**Planning Department  
Transportation Development Services**

**Re: Stormax Storage Additions  
101-106 Mescalero NW  
Traffic Circulation Layout**  
Engineer's/Architect's Stamp dated 3-24-15 (G15-D009)

Based upon the information provided in your submittal received 3-27-15, the above referenced plan cannot be approved for Building Permit until the following comments are addressed:

## TRAFFIC CIRCULATION LAYOUT

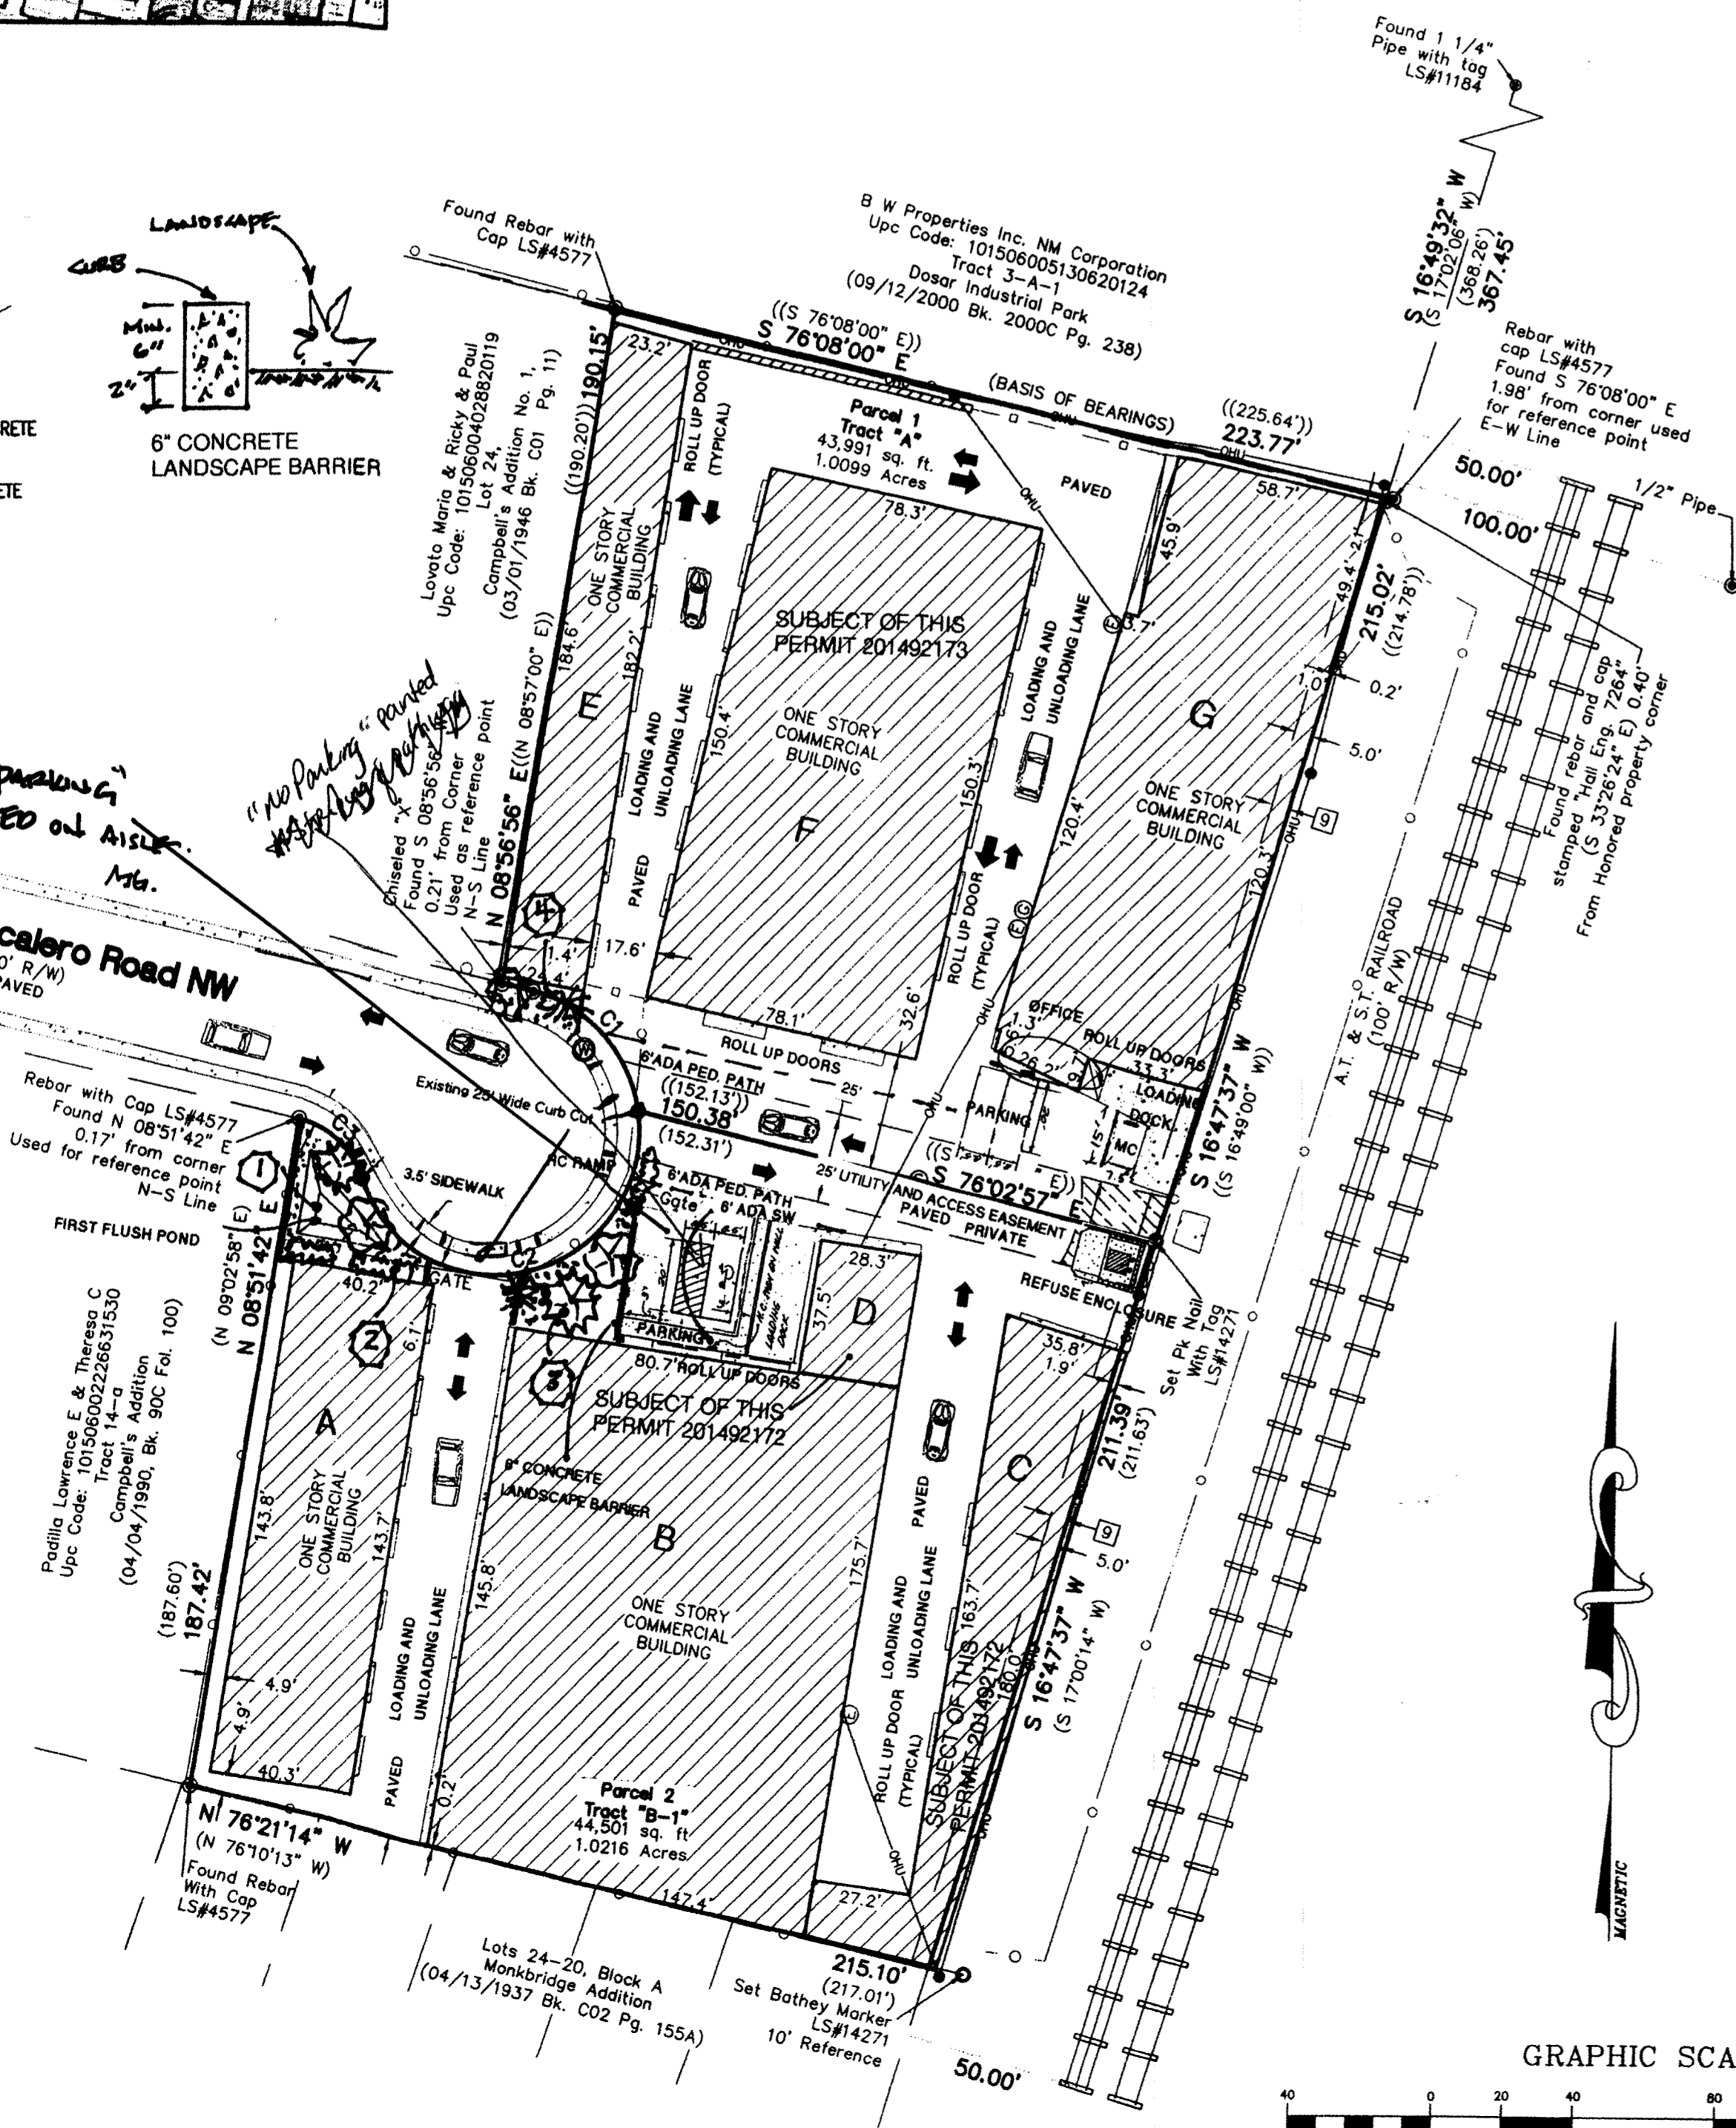
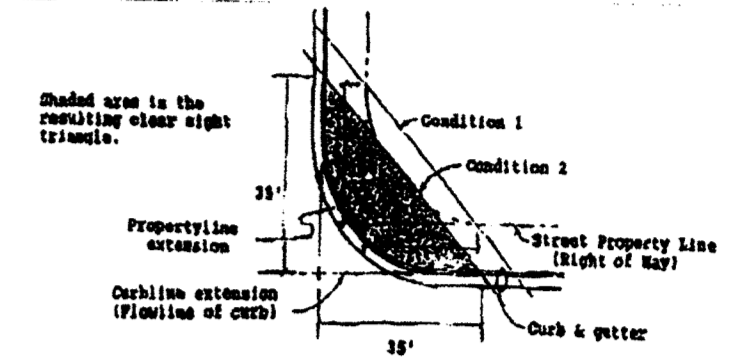
1. Clarify the extents of the current phase. Please identify which buildings or structures are to be considered under this request.
2. Please identify all existing doors, sidewalks, curbs, drive pads, walls and anything that influences the parking and circulation on the site.

3. Please identify pavement surface type(s). A hard driving surface will be required for parking area, drive aisles and pedestrian walkways.
4. All ramps to sidewalks must adhere to 12:1 slope to meet ADA requirements. Please provide detail of ramps from facility driveway entrance to the public sidewalks.

5. Provide a min 6" or max 8" high concrete barrier curb or other acceptable barrier between landscaping and parking areas and/or drive aisles. Please provide detail of landscaping barrier.

6. The ADA van accessible sign must have the required language per 66-7-352.4C NMSA 1978 **"Violators Are Subject to a Fine and/or Towing."**
7. The ADA access aisle shall have the words **"NO PARKING"** in capital letters, each of which shall be at least one foot high and at least two inches wide, placed at the rear of the parking space so as to be close to where an adjacent vehicle's rear tire would be placed. (66-1-4.1.B NMSA 1978)

8. Per the DPM, a 6 ft. wide ADA accessible pedestrian pathway is required from the HC parking stall access aisles to the building entrances.

9. Per the DPM, a 6 ft. wide ADA accessible pedestrian pathway is required from the public sidewalk to the building entrances. Please clearly show this pathway and provide details.

10. Upon review of Traffic Circulation Layout, it is suggested that you utilize the parking spaces in on the south side of building "G" as the dedicated Handicap Parking spaces placing them in front of the facilities office. If left in their current location, it will be required to provide a 6 Ft. wide, unobstructed and clearly demarcated ADA pedestrian walkway. The walk way must be demarcated by means such as special paving, grade separation or pavement marking of a permanent nature such as striping or crosshatched. Please provide detail of handicap pedestrian walkway.

11. Service vehicle and/or refuse vehicle maneuvering must be contained on-site; provide a copy of refuse approval (if applicable).
12. Please provide a sight distance exhibit (see the *Development Process Manual, Chapter 23, Section 3, Part D.5 Intersection Sight Distance*).

13. Please add the following note to the clear sight triangle: "Landscaping and signage will not interfere with clear sight requirements. Therefore, signs, walls, trees, and shrubbery between 3 and 8 feet tall (as measured from the gutter pan) will not be acceptable in this area."

14. One-way vehicular paths require pavement directional signage and a posted "Do Not Enter" sign at the point of egress. It appears that for Buildings E, F and G that the drive path is one-way. Please provide detail of signage.

15. Please add the following note to the clear sight triangle: "Landscaping and signage will not interfere with clear sight requirements. Therefore, signs, walls, trees, and shrubbery between 3 and 8 feet tall (as measured from the gutter pan) will not be acceptable in this area."

16. Please specify the City Standard Drawing Number when applicable.
17. Please include a copy of your shared access and parking agreement with the adjacent property. (If applicable)
